Sydney Theatre Company- State Significant Development Application Summary of Submissions

Submission from	Issues Raised	Response
Agency Submissions		
Department of Planning & Environment	<u>Scope of Work</u> <ul style="list-style-type: none"> Clarification of the scope of work is required as the EIS and supporting appendices do not appear to be consistent. For example the submitted Noise and Vibration Report makes reference to remedial works being undertaken to the heritage façade, however this is not included in the EIS scope of work. 	<ul style="list-style-type: none"> All consultants to check reports for consistency with STC scope of work. All references to works as part of WBAP project to be removed other than cumulative impact assessment.
	<u>Bicycle Storage / Bicycle Parking</u> <ul style="list-style-type: none"> Consideration should be given to the provision of secure bicycle storage facilities and to providing dedicated bicycle parking on site 	<ul style="list-style-type: none"> In both STC and the Walsh Bay Arts Precinct (WBAP) SSDAs, 25 bicycle spaces for staff (for the whole precinct inclusive of STC) are proposed. For the WBAP SSDA, a bicycle parking provision rate of t

Figure 24: Proposed Level 1 Plan by Hassell. Highlighted in blue WBAP scope (SDD 16-7689).

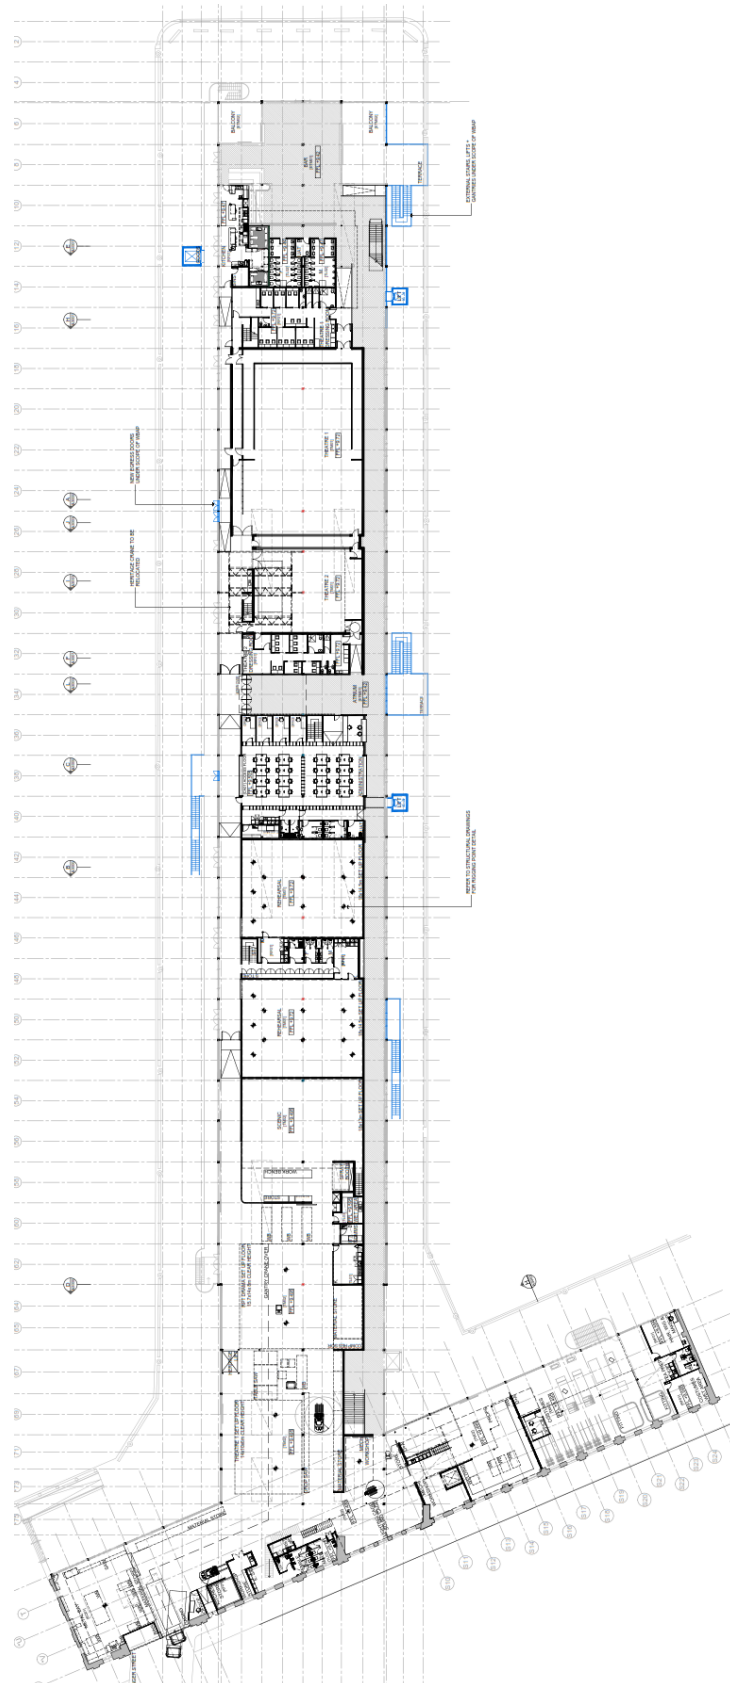
<u>Revised Plans</u> <ul style="list-style-type: none"> Level 1 plan refers to lift as being a heritage lift. The plan shall be amended to detail the heritage lift as either being retained or removed Level 2 heritage impact plan incorporates a note stating the extent of heritage significance and structure of wall to be confirmed. The plan shall be amended to detail the wall as having significance, alternatively the annotation shall be deleted Provide revised plans which detailed finished floor levels and 	<ul style="list-style-type: none"> Amended plans prepared and provided at Appendix 2. Level 1 plan clarifies heritage lift to be retained. This matter has been addressed in the revised Heritage Impact Statement at Appendix 5. Finished floor levels shown on plans. Plans have been prepared to scale.
